Oakdale West Estate Stage 3 (SSD 9794683)– Response to Request for further information

We write on behalf of *Goodman Property Services (Aust.) Pty Ltd* (the Applicant) in relation to the amended State Significant Development (SSD) application for Stage 3 of Oakdale West Estate SSD 9794683 (Amended Application).

Response to Agency Submissions

01 Carpark Tree Pit System  
Detailed Plan - Scale 1:100 @ A1

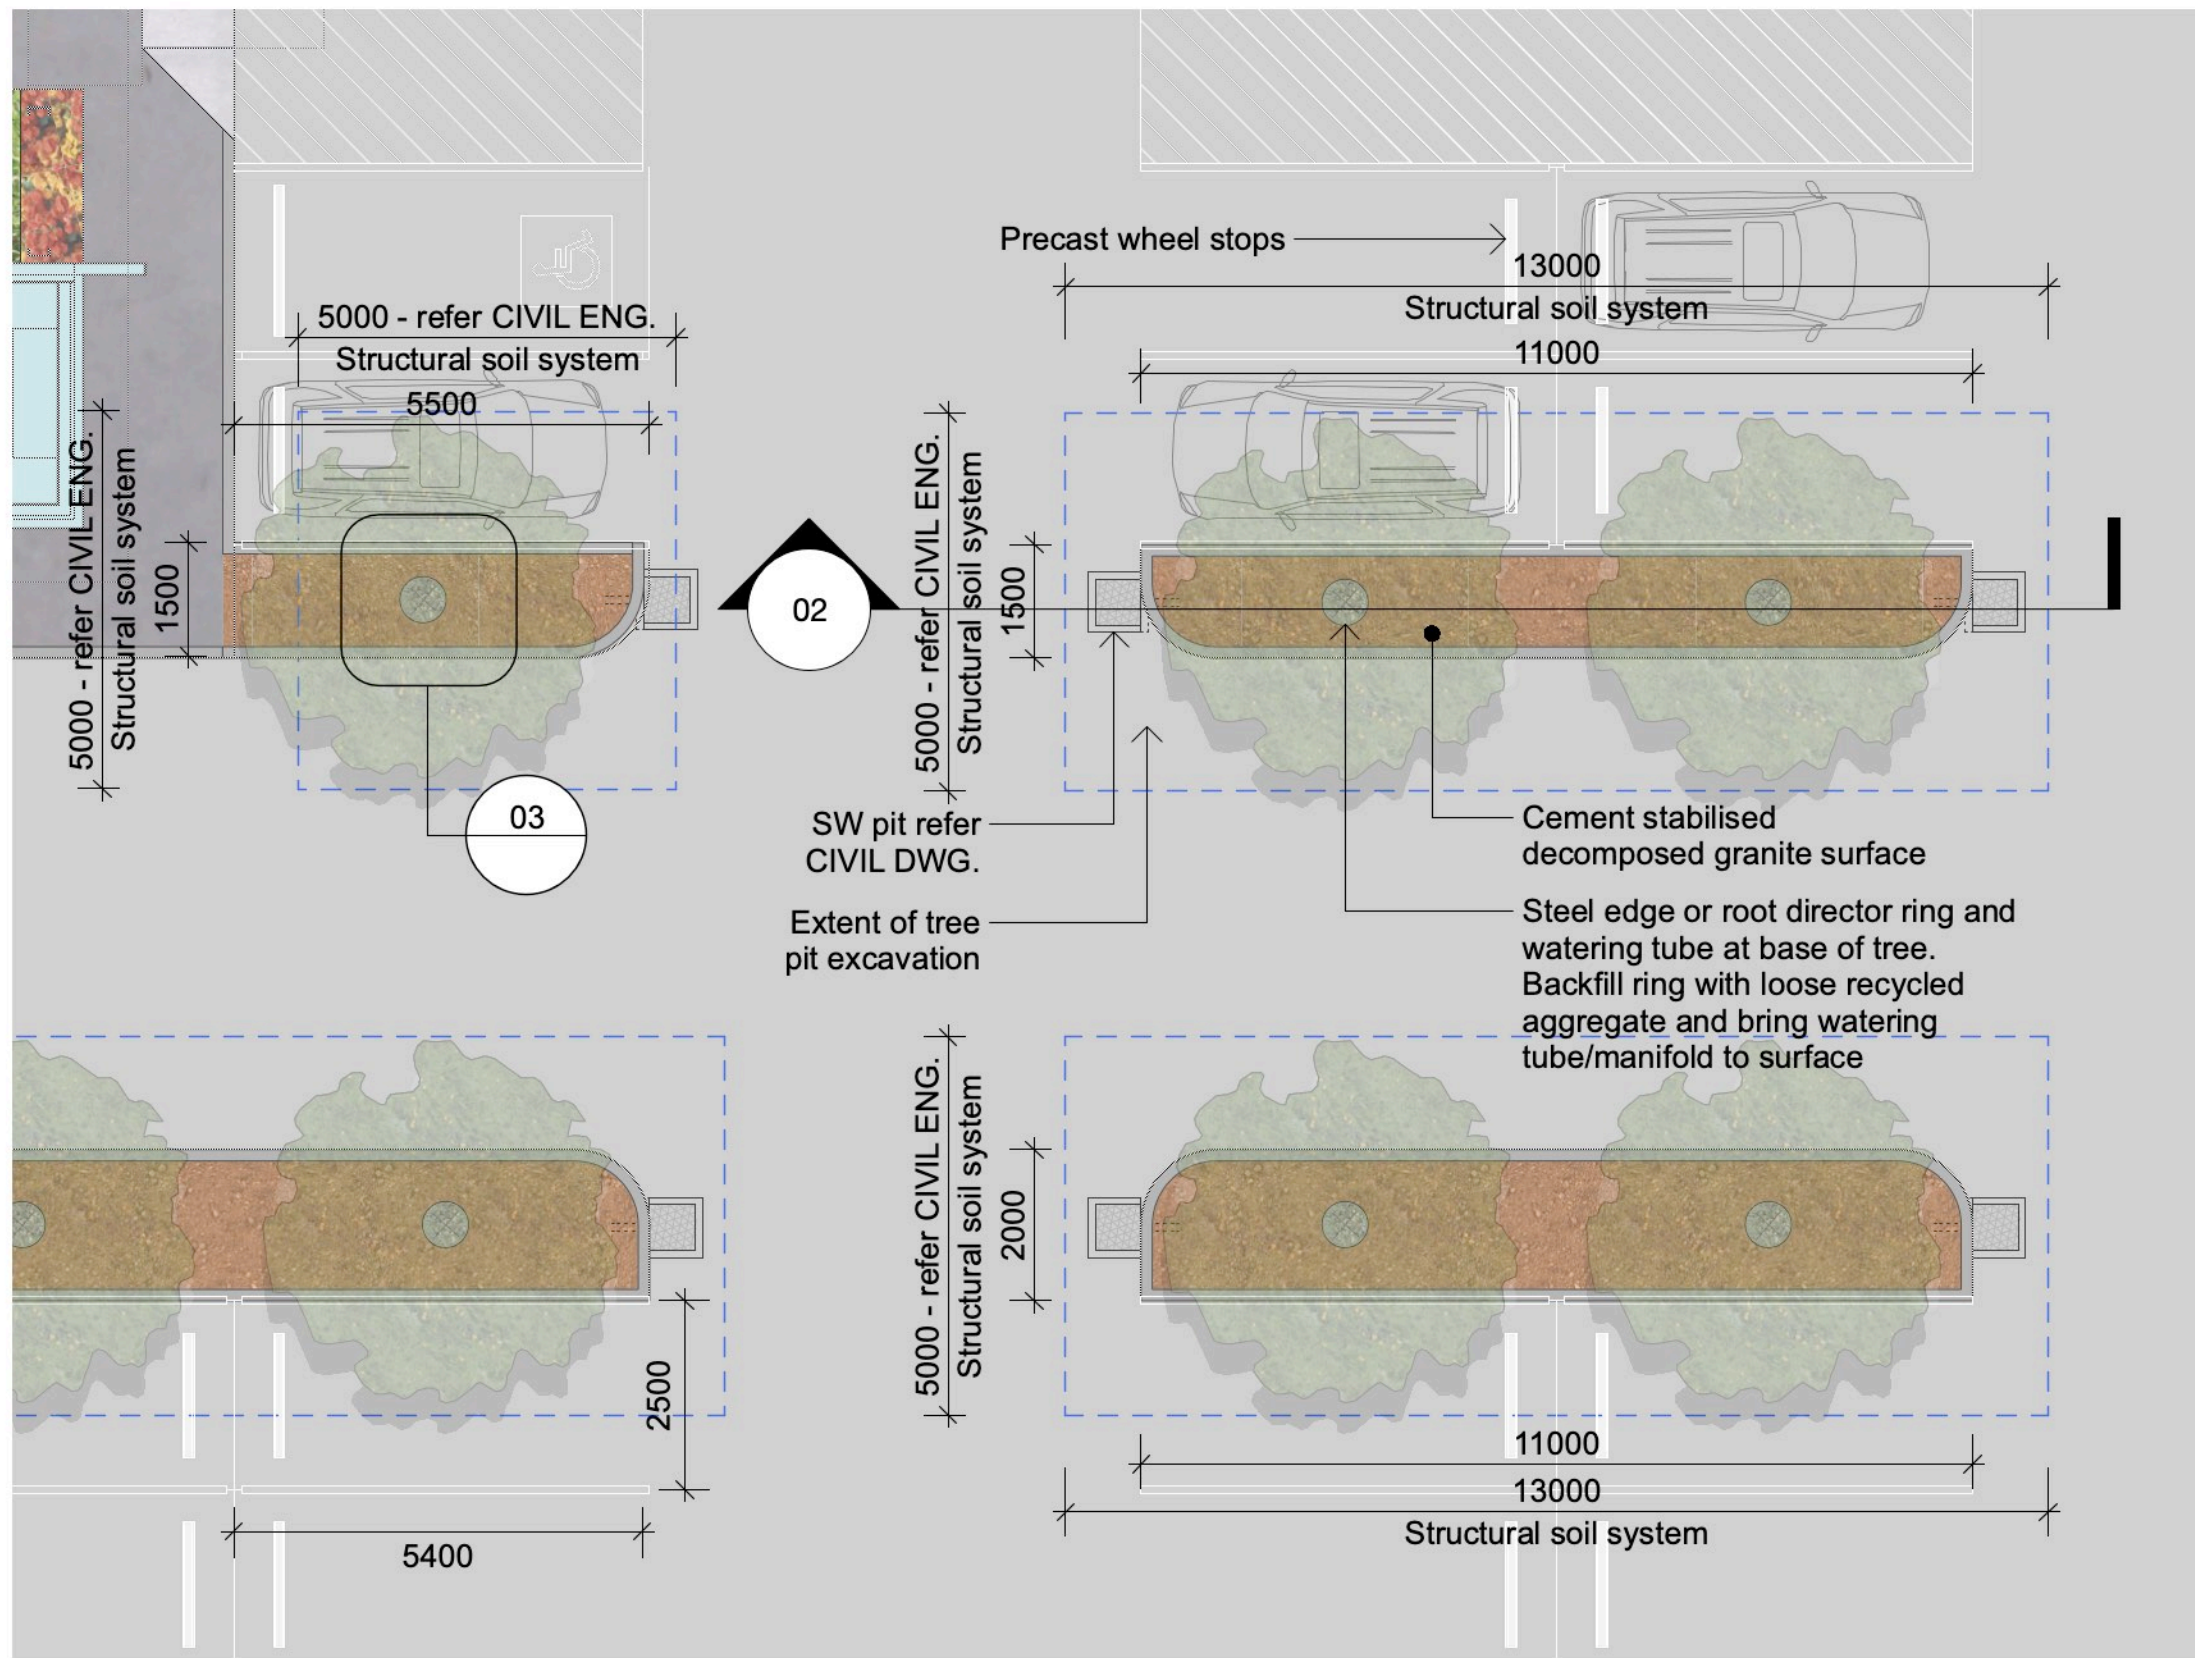
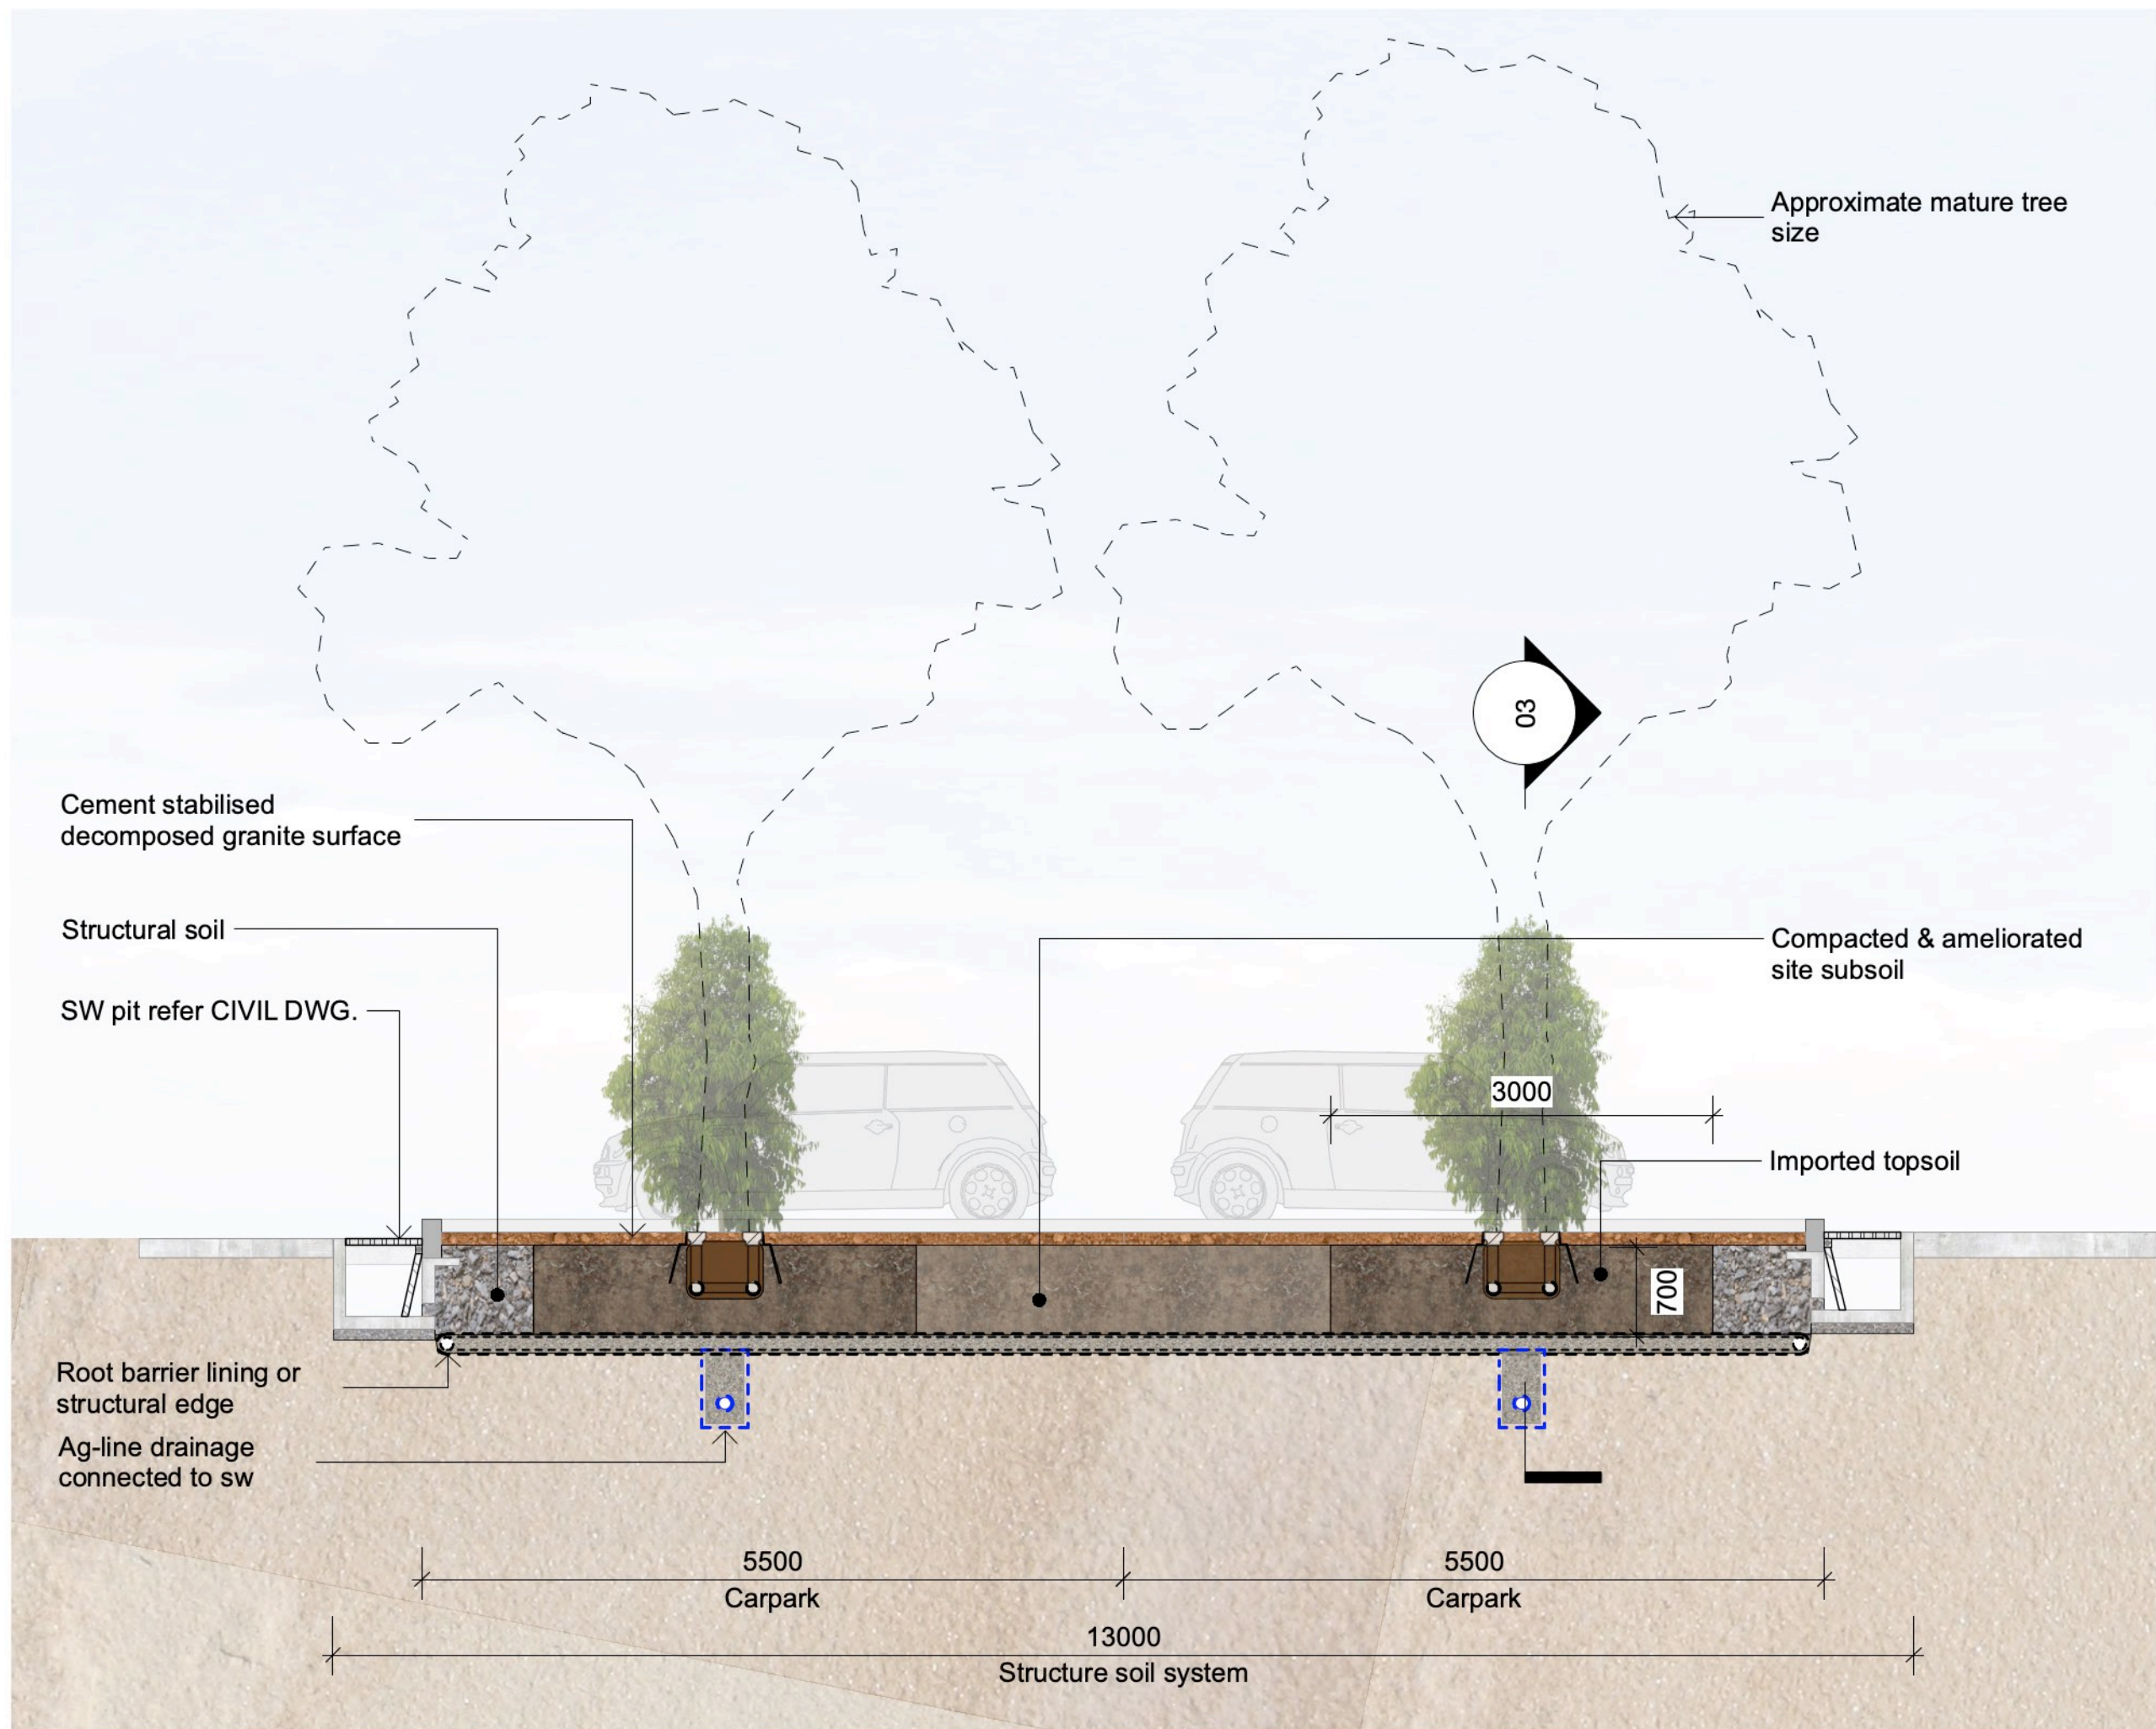
PCC Issue	Comment/Response
<ul style="list-style-type: none"> • Tree plantings in the pavement at Lot 2D and carpark areas were previously supported, provided that a suitably qualified and experienced arborist specifies the engineered tree pit details including structural soil volumes and materials, based on proposed species. This was suggested so as to ensure the best possible growing conditions for long term tree health and viability (refer sheet LSK.200) • Section 03/LSK.202 is misleading in terms of retaining wall height. Spot levels indicate a change in level of approx. 8m. The section shows a wall height of approx. 2m. All retaining walls and fences on top of walls, seen from the public domain, should be densely screened to reduce visual impact and create microclimates suitable for plant growth e.g. not radiated heat from wall materials. • With respect to Estate Road 1 (Sepia), increased shrub and screening is required to maximise streetscape amenity and reduce visual access to roadways and vehicles /trucks • Organic mulches should be used for soil improvement and plant health, not inorganic mulches such as basalt. This could be addressed via conditions of consent applied by the Department. • With respect to the raised feature treatments with gabion walls, an arborist must inform and determine suitable dimensions of soil volumes and other treatments to ensure the best possible growing conditions for long term tree and plant health and viability (refer sheet LSK.201) • The proposed extent of cut and fill requires a reconstruction of soil profiles to enable planting to establish and thrive in the long term. Details have not been provided. Planting into fill and sub-soils without amelioration and reconstruction will result in stunted, unhealthy and compromised vegetation.
